From: Amanda Scholes on behalf of Planning.Responses
Sent: 08 June 2020 11:50
To: Planning Scanning
Subject: FW: 2020-05-15-19163-PARCELS A2 & B6, Littlehampton - Drainage Drawings

Comments;

Subject: 2020-05-15-19163-PARCELS A2 & B6, Littlehampton - Drainage Drawings

Hydro-Brake Control Chamber HB2

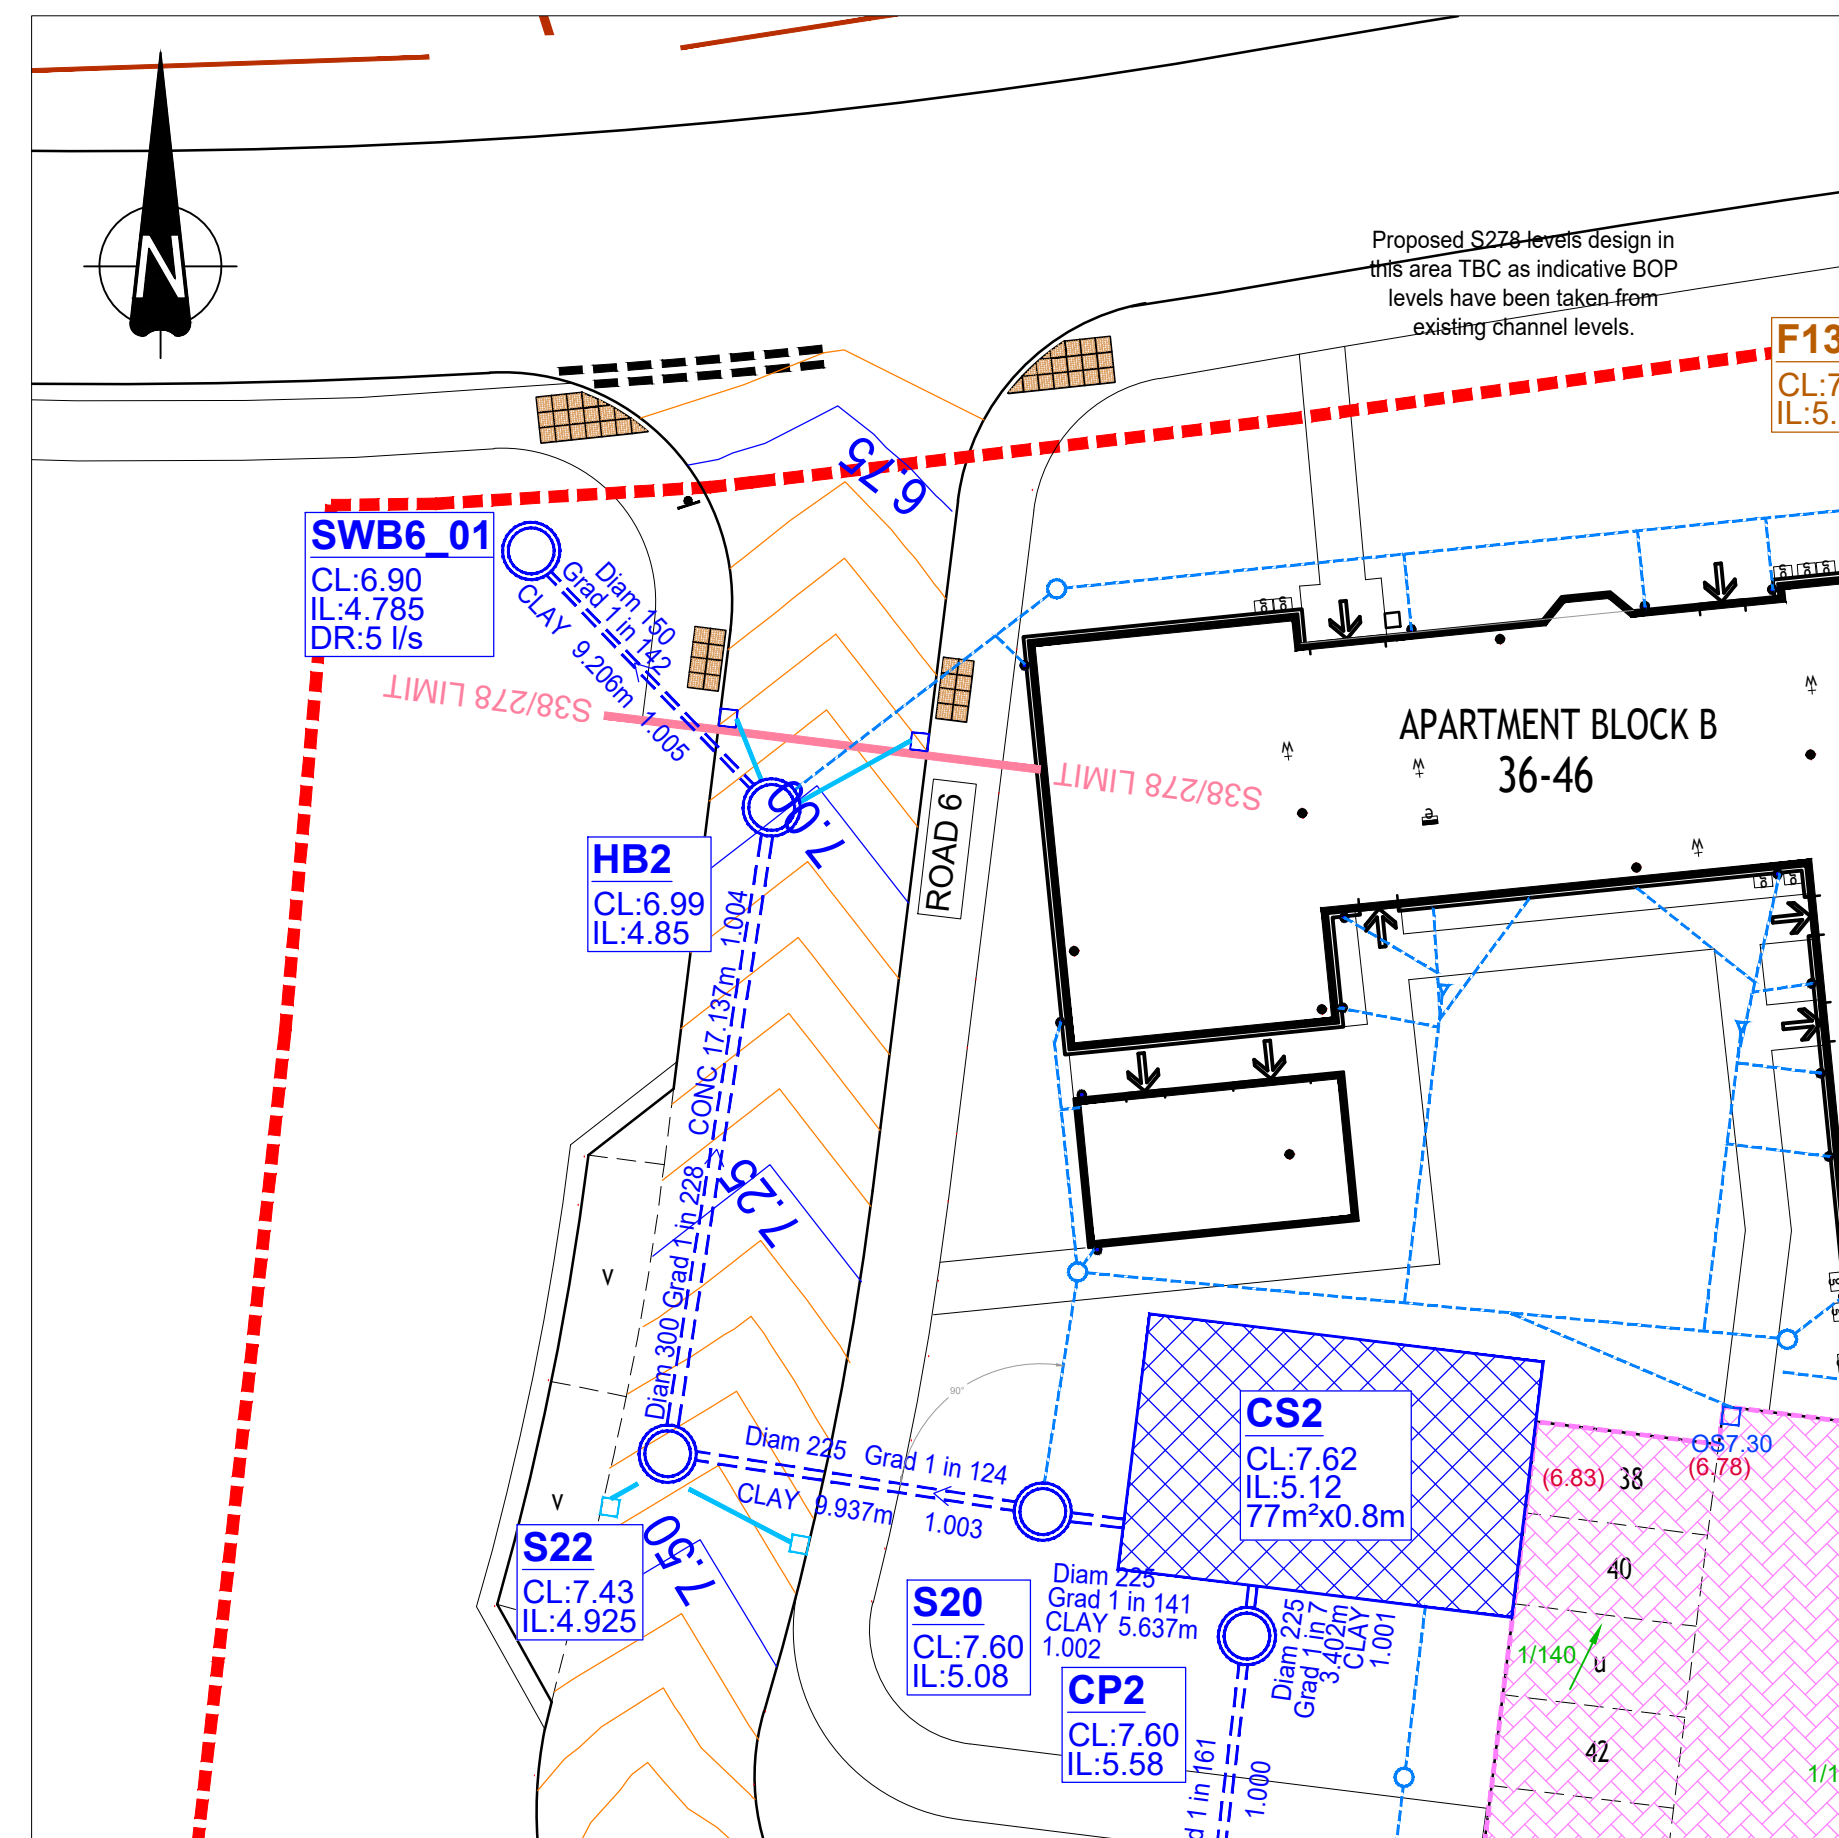
5. Hydrobrake chamber HB02 construction detail – plan view shows incoming 900mm pipe as opposed to 300mm and 1.8m dia rings as opposed to 1.5 dia. Incoming 150mm connections to connect soffit to soffit with 300mm pipe. The gully that is connecting against flow and above hydrobrake is not ideal but willing to accept it in this instance (Section A-A shows it in a different location to the plan view?) *ok*

6. Both hydrobrake chambers – show base thickness/reinforcement details. *ok*
7. Existing manhole SW03A – just upstream of SWA2_01 – what is its purpose? Invert level is lower than the downstream manhole. Please clarify if it is required and adjust as necessary. *Removed - ok*
